**From:** Clare Whitehead  
**Sent:** 05 February 2020 09:13  
**To:** DC Support  
**Subject:** FW: 19/02550/F

**From:** Charlotte Watkins <Charlotte.Watkins@Cherwell-DC.gov.uk>  
**Sent:** 05 February 2020 08:57  
**To:** Clare Whitehead <Clare.Whitehead@Cherwell-DC.gov.uk>  
**Subject:** 19/02550/F

19/02550/F  
Land to the East of M40 and South of A4095, Chesterton, Bicester

**Proposed Site Plan**

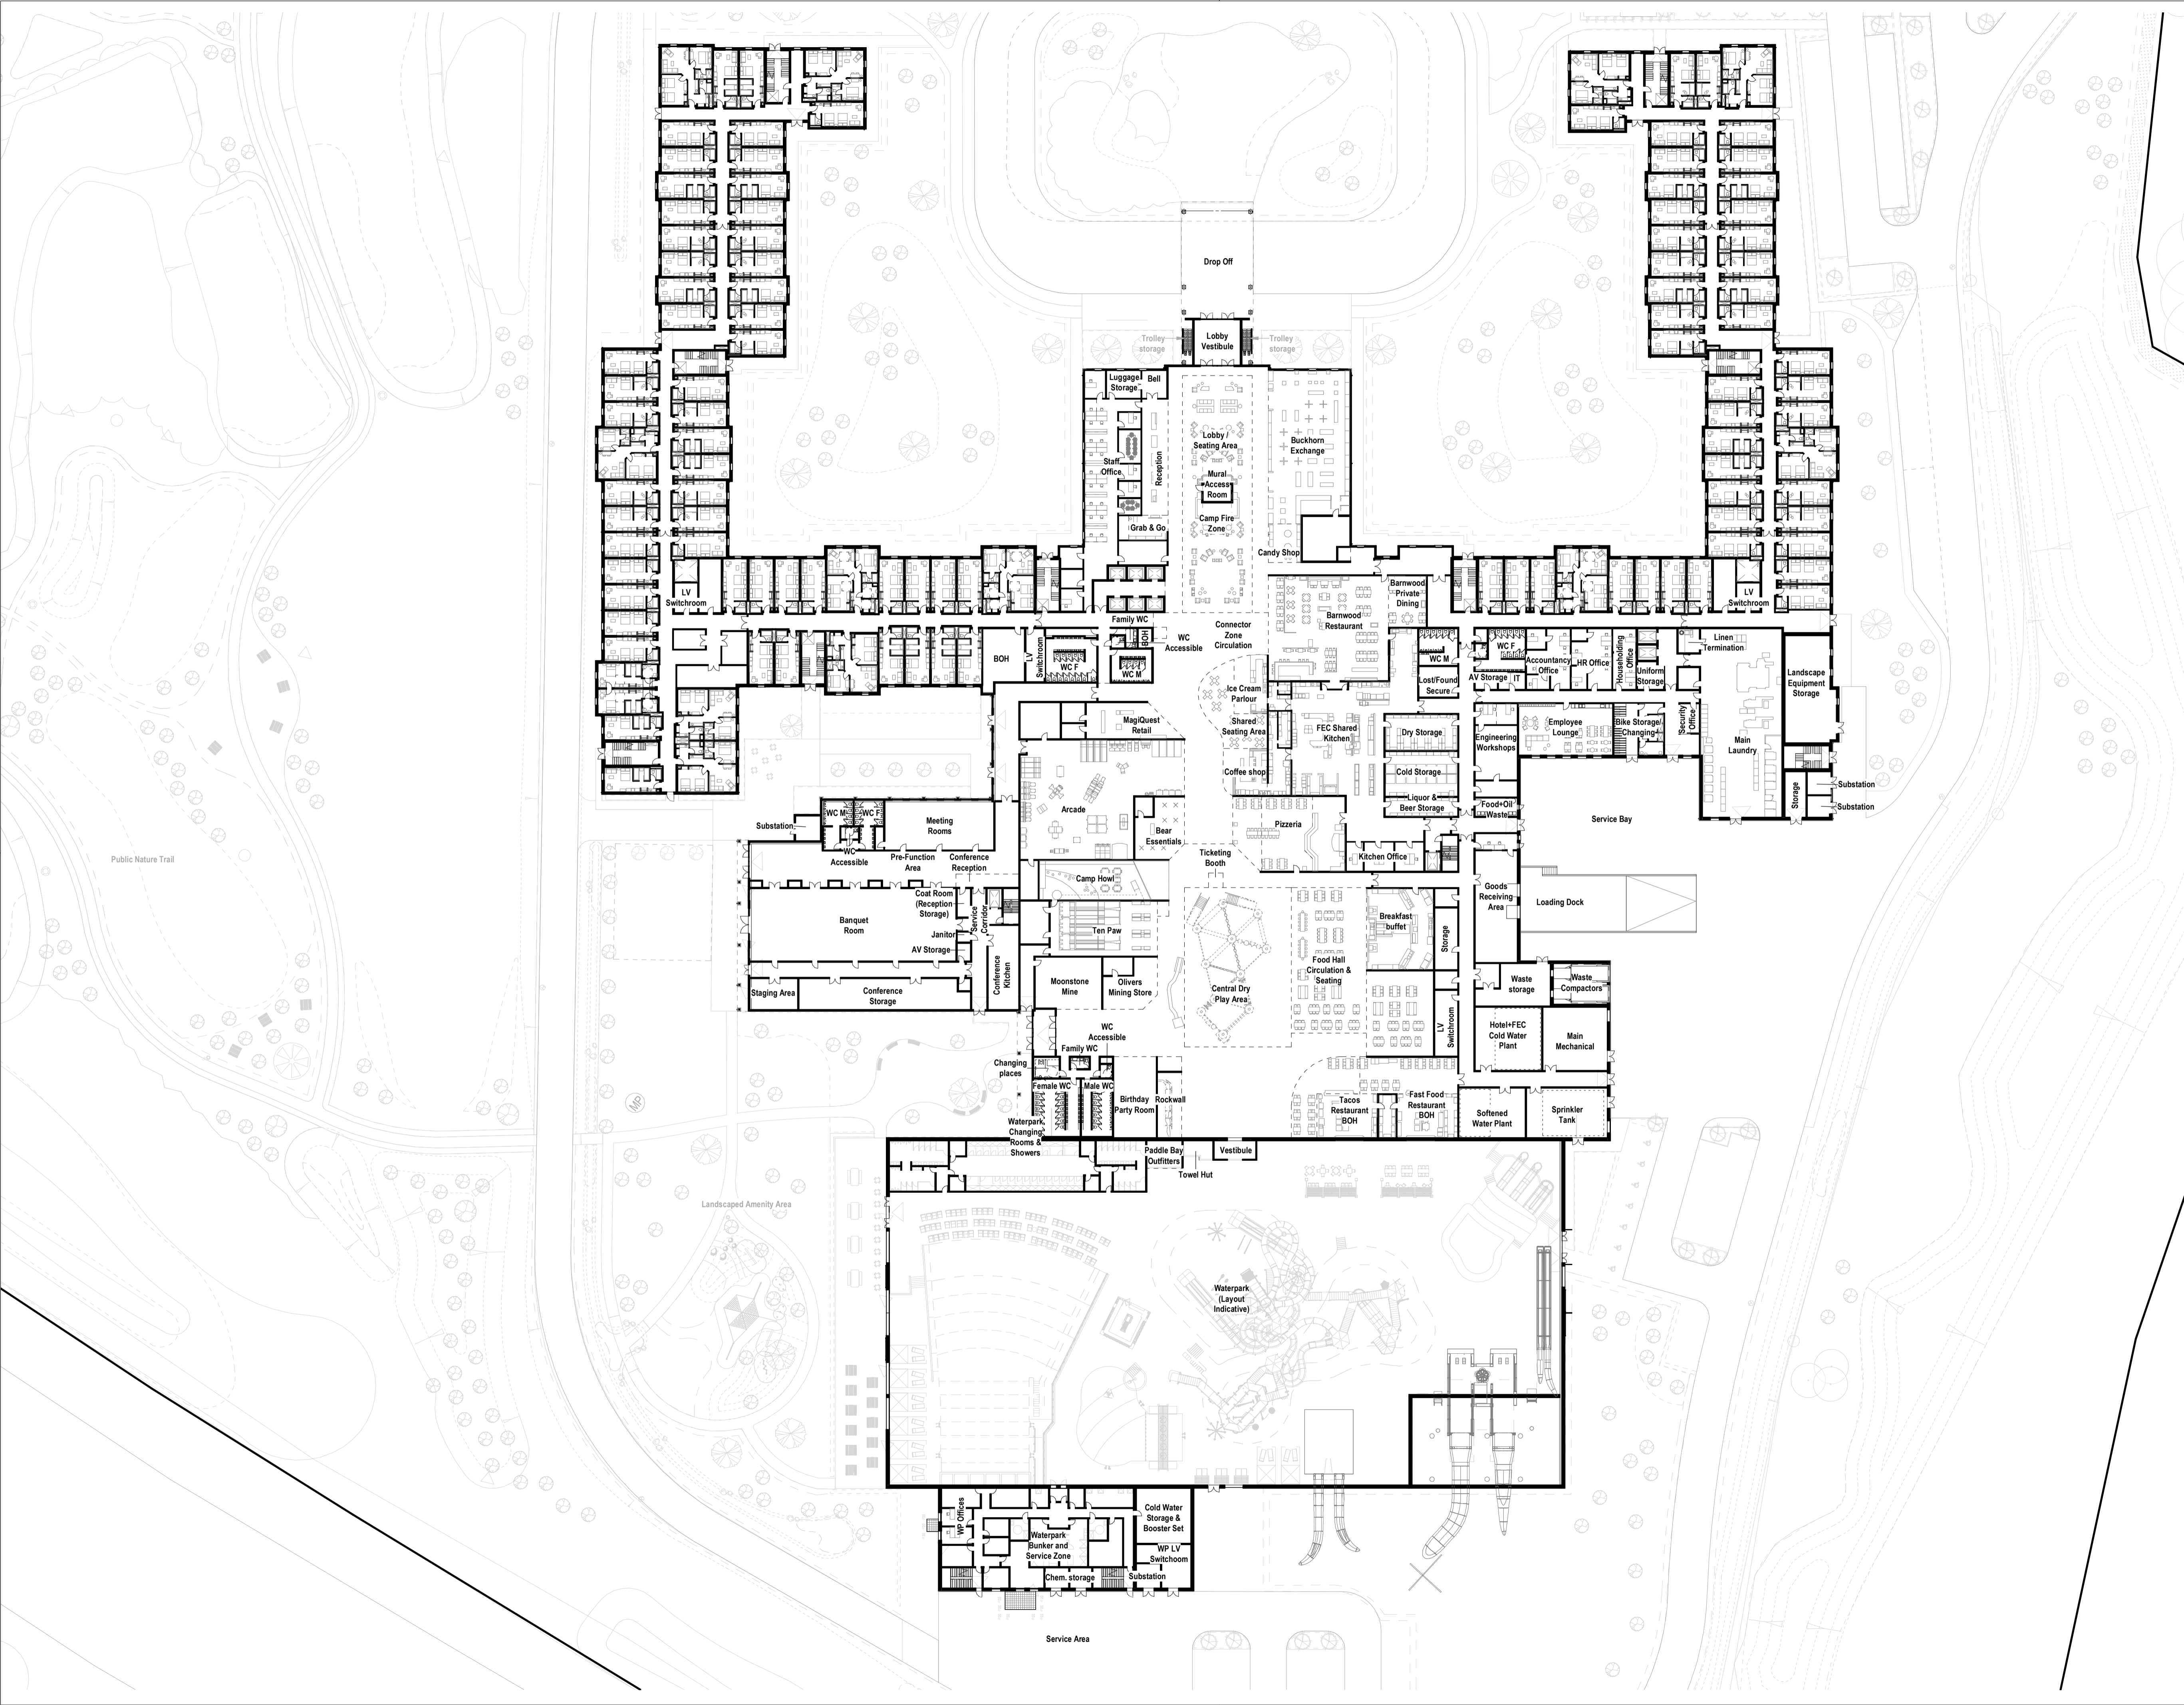
The opportunity to created higher value habitat as mitigation and enhancement has been taken mainly in the green space to the West of the main buildings. Some of the proposed habitat creation may be difficult to create and maintain in the long term – a large part of the semi-improved grassland for example is within the area from the buildings to the carpark where managing it for wildlife benefit may conflict with other needs. I can't tell if calculations for 'scrub' includes small areas of ornamental planting around the carpark which may be of limited

value – these are marked as scrub in the post-development habitat map. Similarly with the low (1.2m) hedging proposed within the large carpark area. This should be clarified.

The large strip of amenity grassland to the Southern edge of the buildings would be better replaced with other grassland which would better maintain a wildlife connection between the (current) two halves of the golf course. Currently the placement of the buildings isolates the two halves to some extent.

**Figure 4 – Phase 1 Habitat Survey Results**

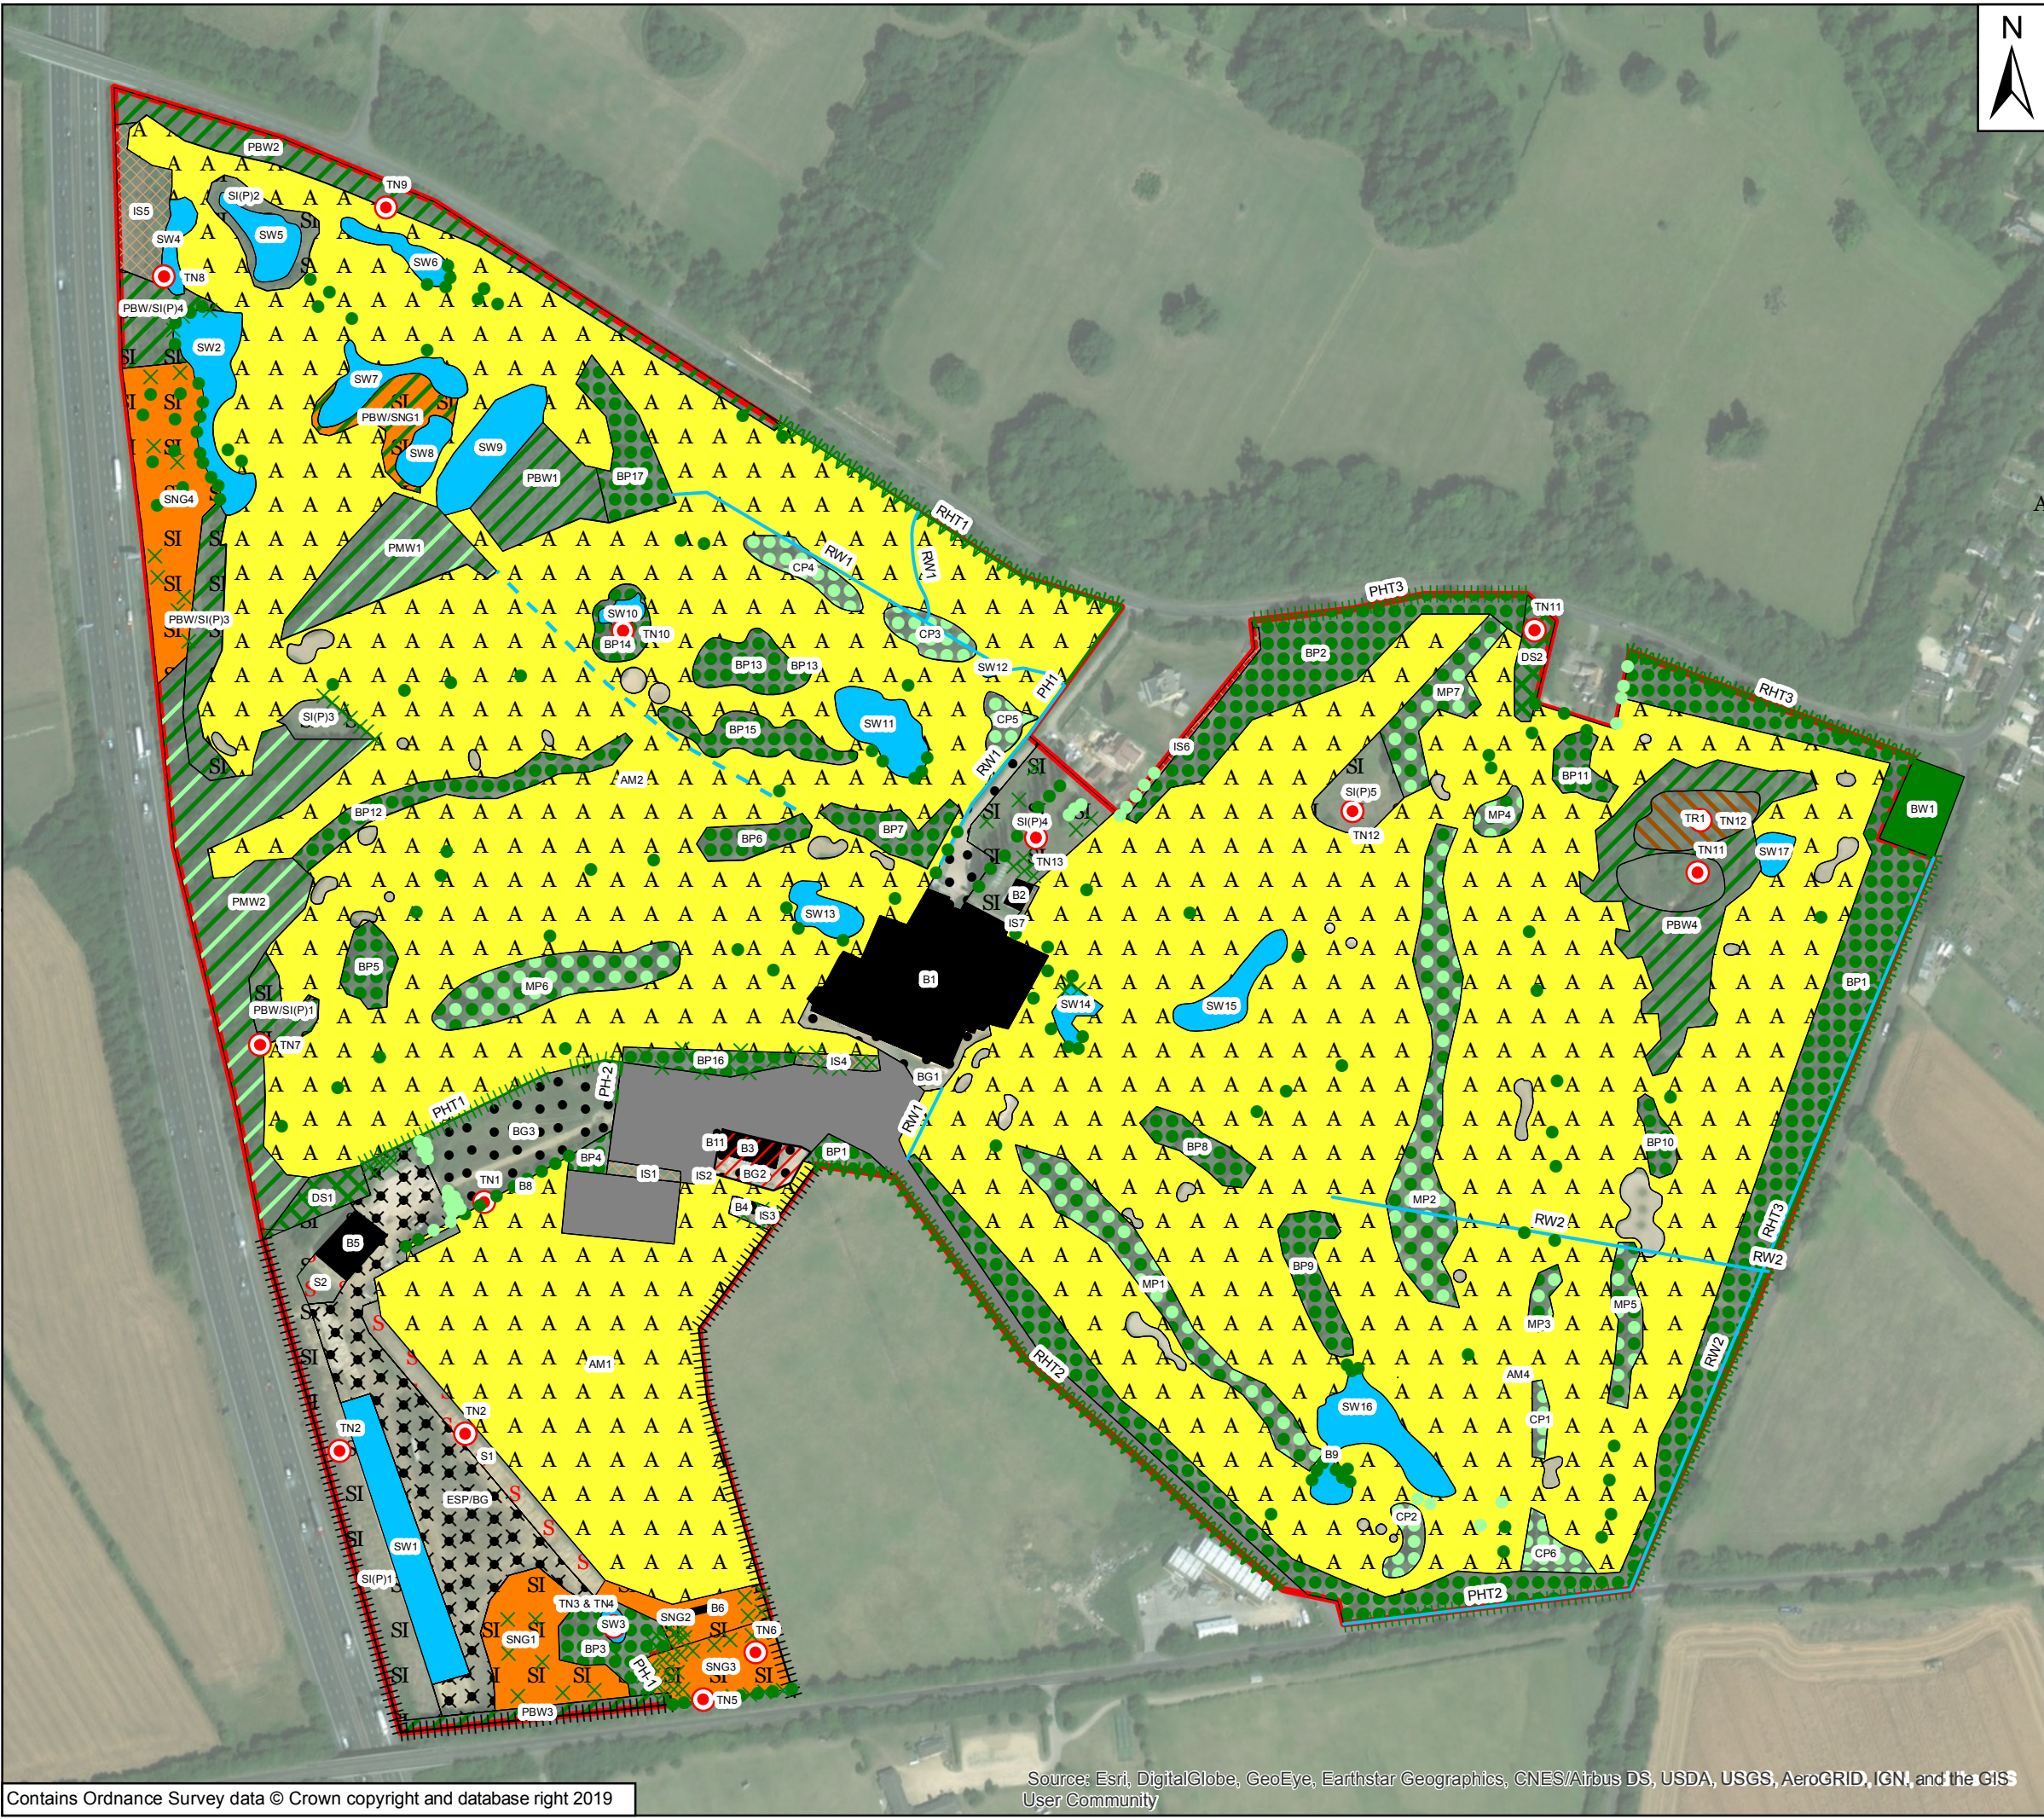
They have rated all the current habitats as 'poor' and there is some loss of important habitats long term, namely running water. The net gain calculation summary states these are ditches which are often dry and will be replaced by swales however the Phase 1 survey report states there is a small stream (RW1) which looks to also be being lost and I wonder if this is accounted for? I couldn't find anything else on this.

The concerns above could be addressed in a modified lighting plan, making it clear which aspects are included in their net gain, showing where RW1 is accounted for and by a conditioned **LEMP** which takes recreational pressure and its management into account. The net gain calculation will need updating if there are any changes.
